WEST SUSSEX COUNTY COUNCIL CONSULTATION

TO:	Arun District Council FAO: Michael Eastham
FROM:	WSCC - Highway Authority
DATE:	16 February 2022
LOCATION:	Land north of Toddington Lane (adjacent to Lyminster Bypass) Hampton Park Littlehampton BN17 7PP
SUBJECT:	LU/417/21/OUT Outline application with some matters reserved (except access) for the erection of up to 71 No dwellings.
DATE OF SITE VISIT:	n/a (desktop study)
RECOMMENDATION:	More Information Required
S106 CONTRIBUTION TOTAL:	TBA

This is the WSCC County Highways (CHA) response to the above outline planning application with some matters reserved (except access) for the erection of up to 71 dwellings.

JOB TITLE		CLIENT	
Toddington Lane, Littlehampton		T & L Crawley No.2 LLP	
DRAWING TITLE			
Site Access Visibility Splays			
SCALE	DRAWN BY	DATE	DRAWING No
1/2500A3	BP	Oct21	23104-01
REVISION

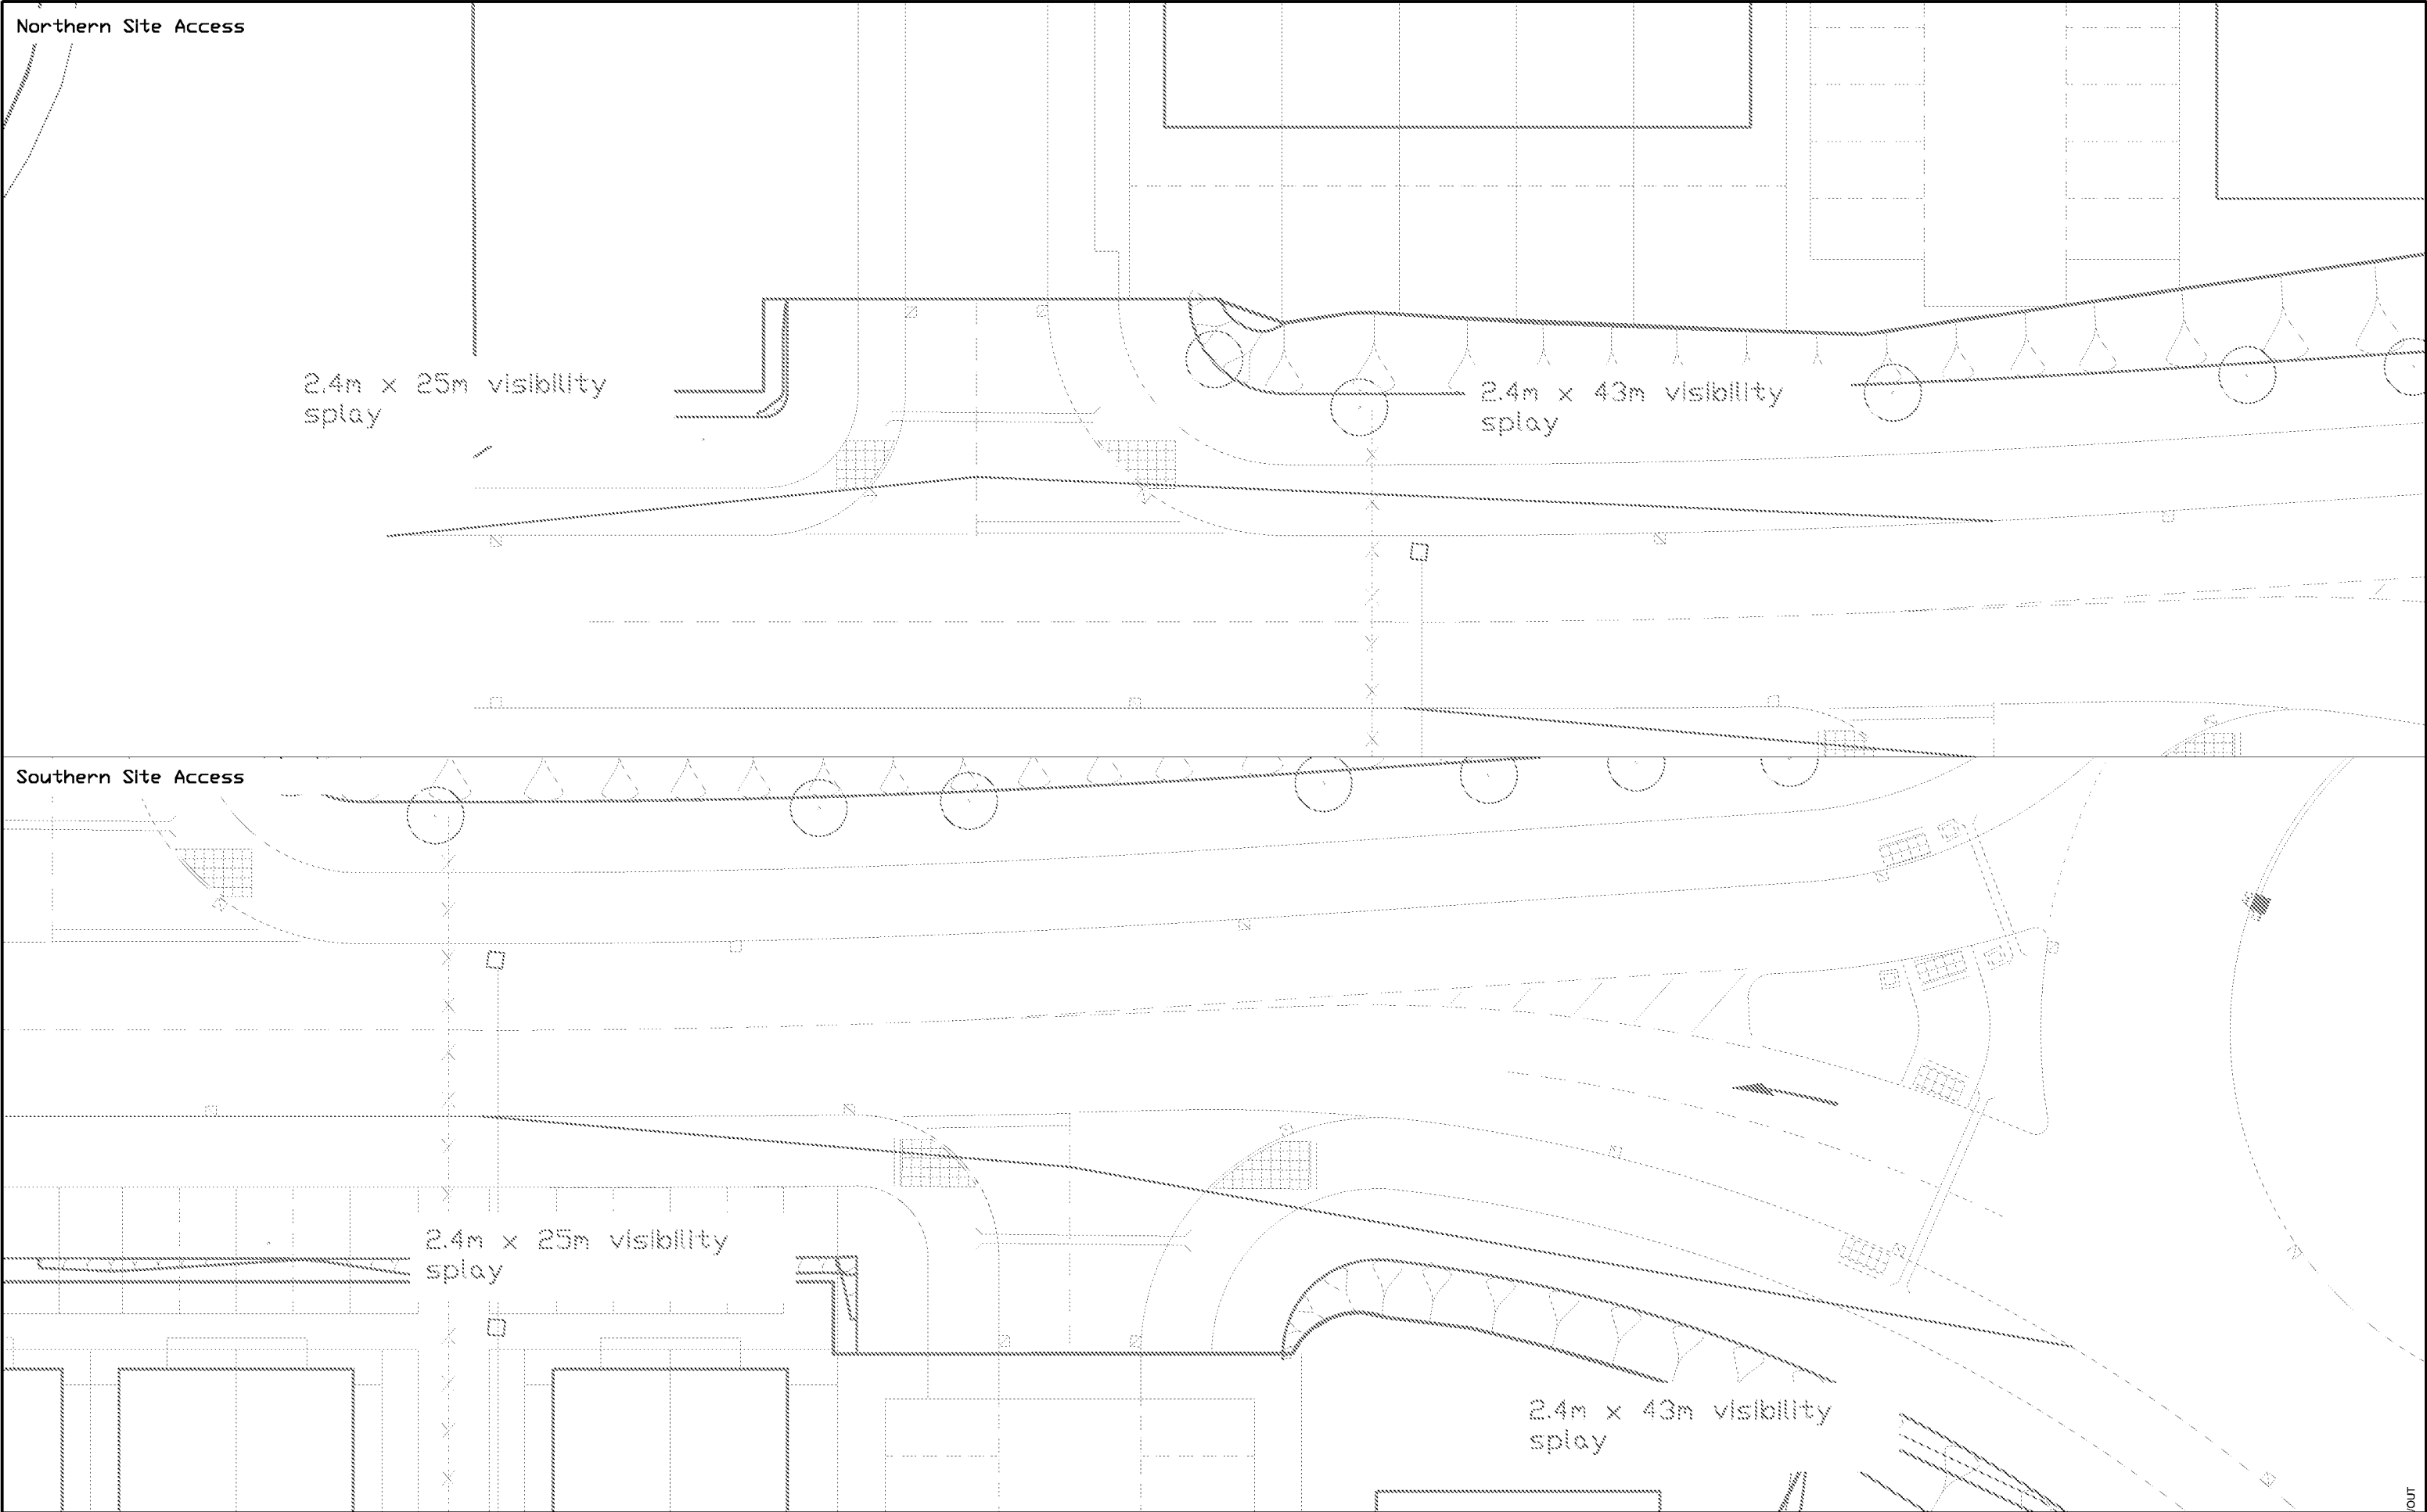
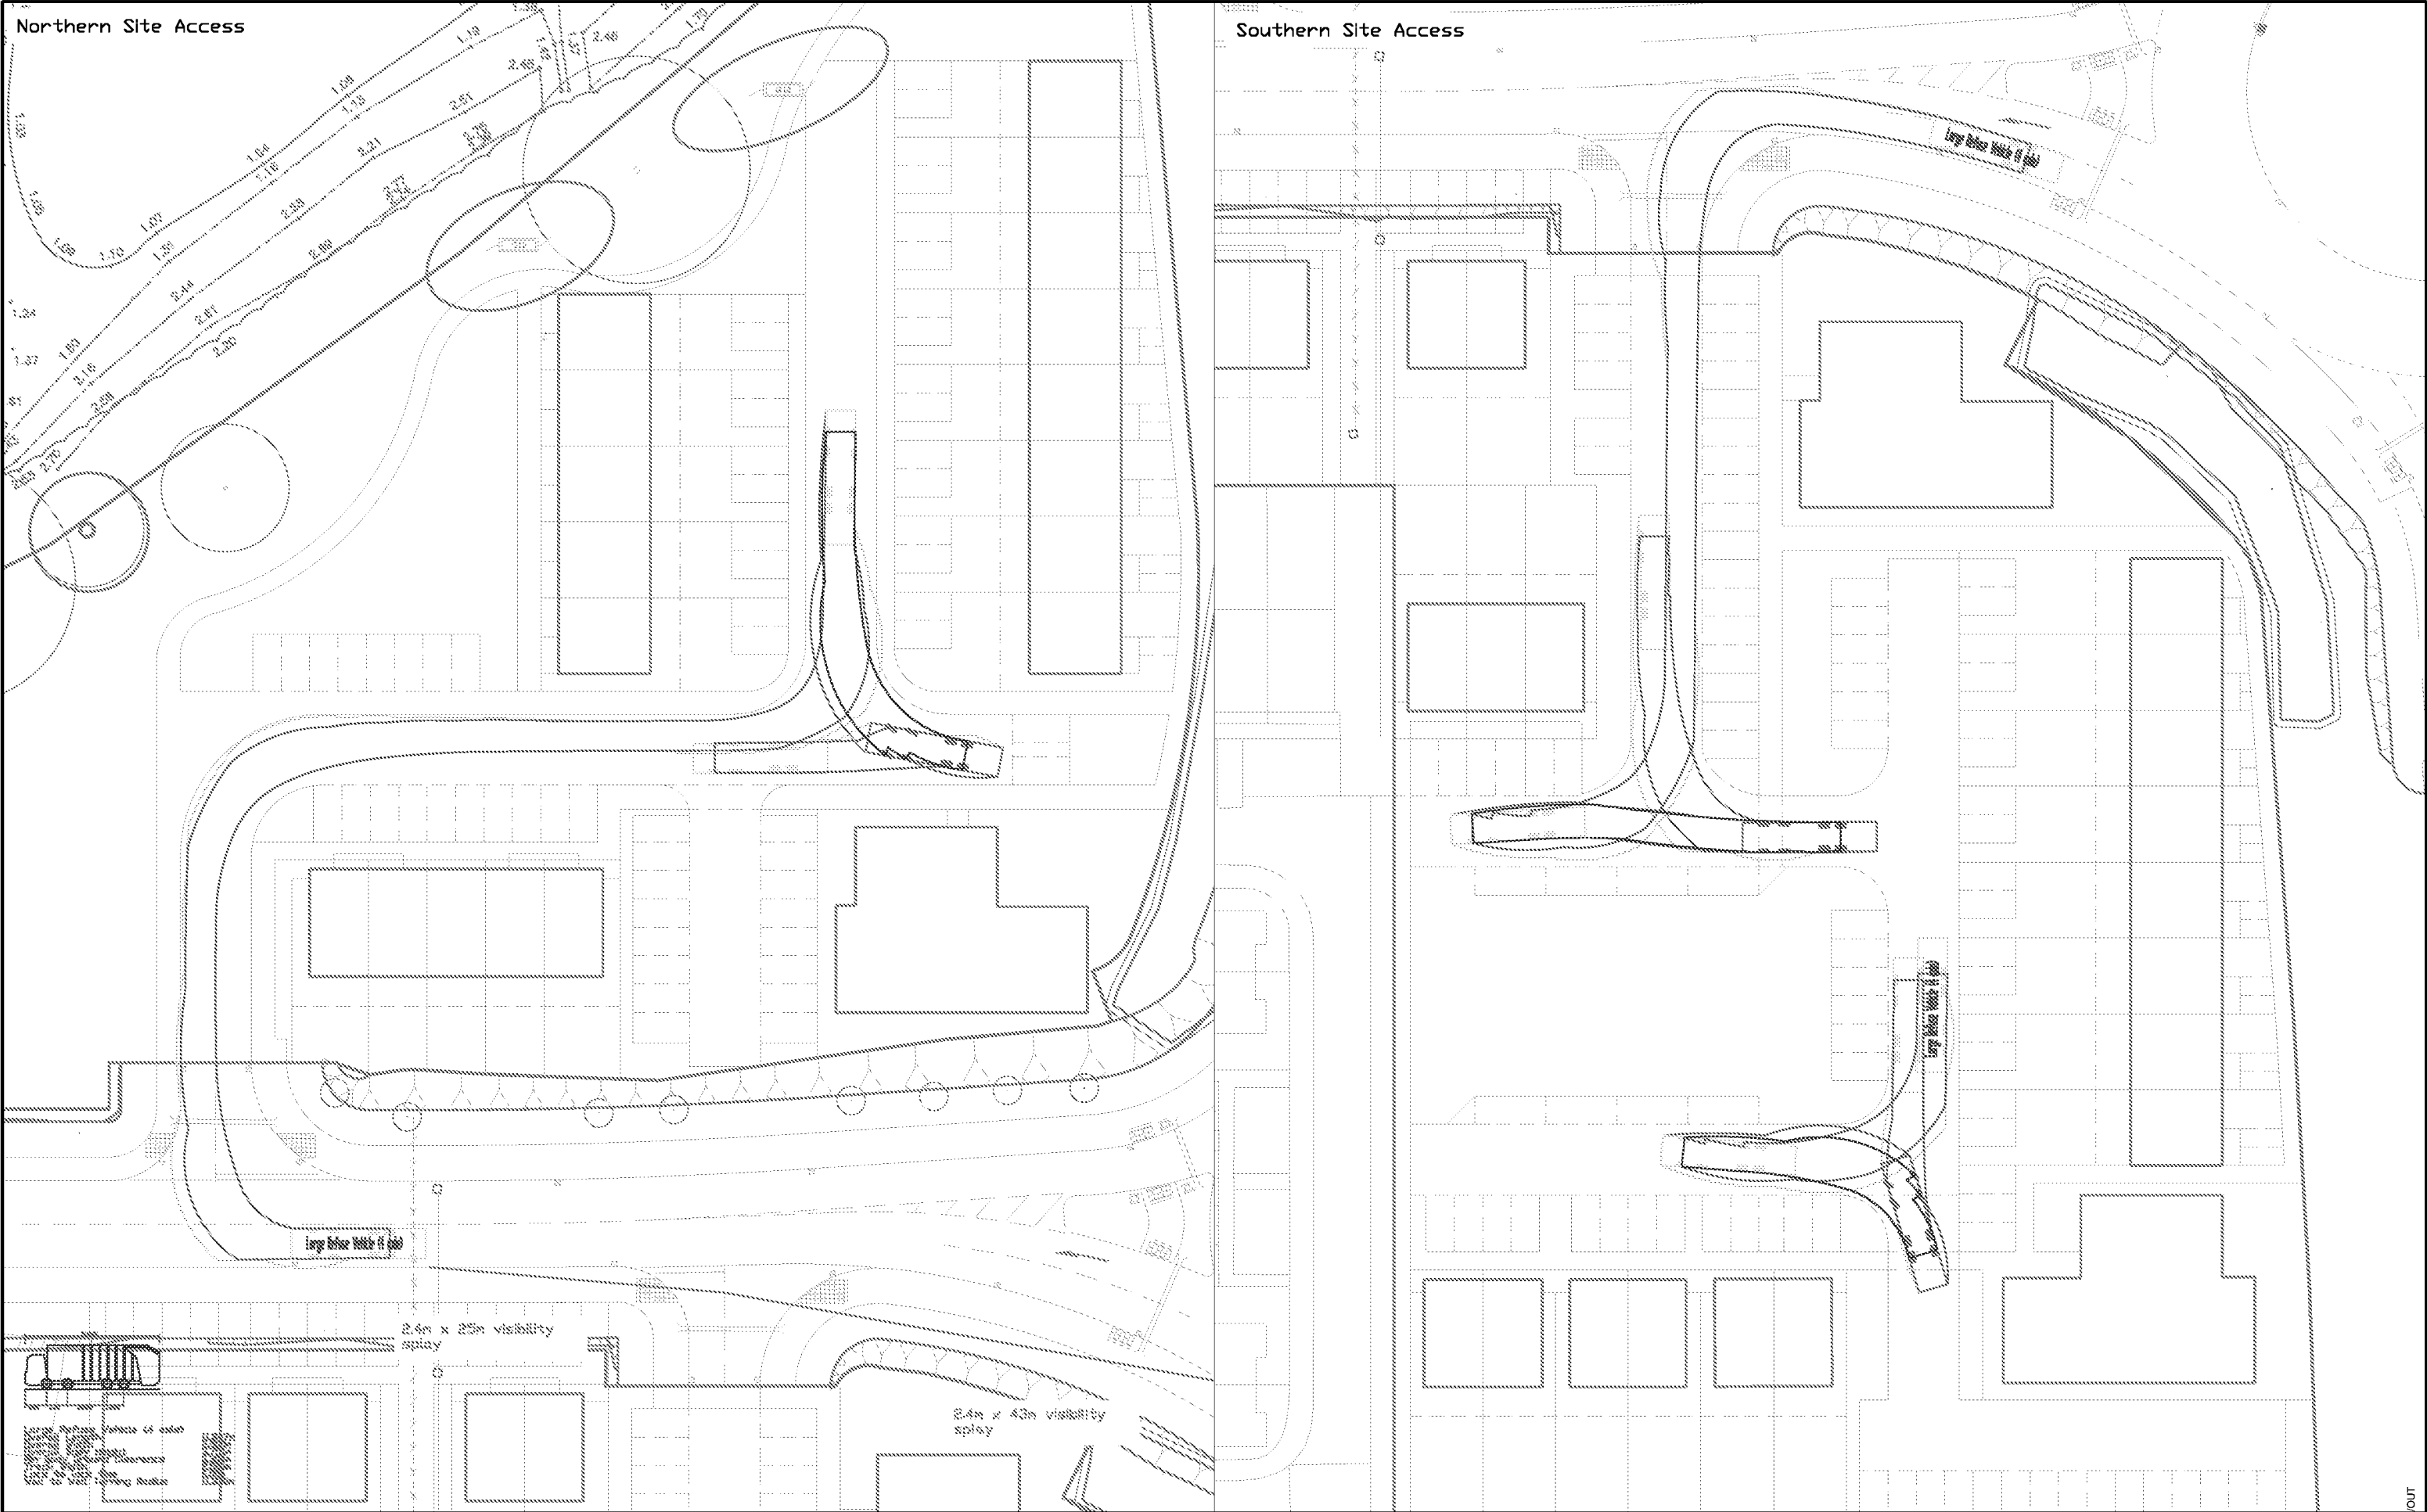
As mentioned above, vehicular access is shown taken off a spur road running E-W from the new roundabout found at the northernmost part of the developer-led section of the new Lyminster By-Pass. Both access points are shown constructed as formal junctions with bellmouth radii and associated kerbing. For pedestrian and cycle access, this is shown in-part to the site off the formal access points. However, the CHA considers that further attention needs to be paid to this for both sites.

Turning to the vehicular access points, both show insufficient detail of how pedestrians and cyclists would enter and leave the sites. As seen from the submitted drawings, the spur road does provide for off-road shared foot and cycle access to the boundary of each site but what is not shown is how this would be continued into both land parcels. As such, the applicant should provide amended drawings showing how this would be achieved. Furthermore (and in addition to any alterations to the vehicular access points), the applicant should also consider the provision of foot and cycle linkages to and from the site closer to the roundabout junction as this could have the effect of providing more direct routes for non-motorised users.

For the accesses and the changes requested (including those concerning other foot and cycle links to-from the site), the CHA require that all should be safety audited to Stage 1

at this planning stage. A road safety decision log (designer's response) should also accompany the Stage 1 road safety audit.

1. Provision of plans showing improved pedestrian and cycle access design at the vehicular access points
2. Provision of a plan showing additional foot and cycle connections to and from the adjacent walking and cycle paths
3. A Stage 1 road safety audit of all that referred to in points 1 and 2 above (including road safety audit log listing the designer's responses to any recommendations made)
4. Plan showing removal of the informal path running across the northern part of the northern plot and out to the WSCC section of the Lyminster By-Pass
5. Provision of a suitable financial contribution to public transport (bus) access to the site
6. Provision of an updated Travel Plan
7. Comments in response to design of parking provision
8. Comments in response to comments made about EV installation
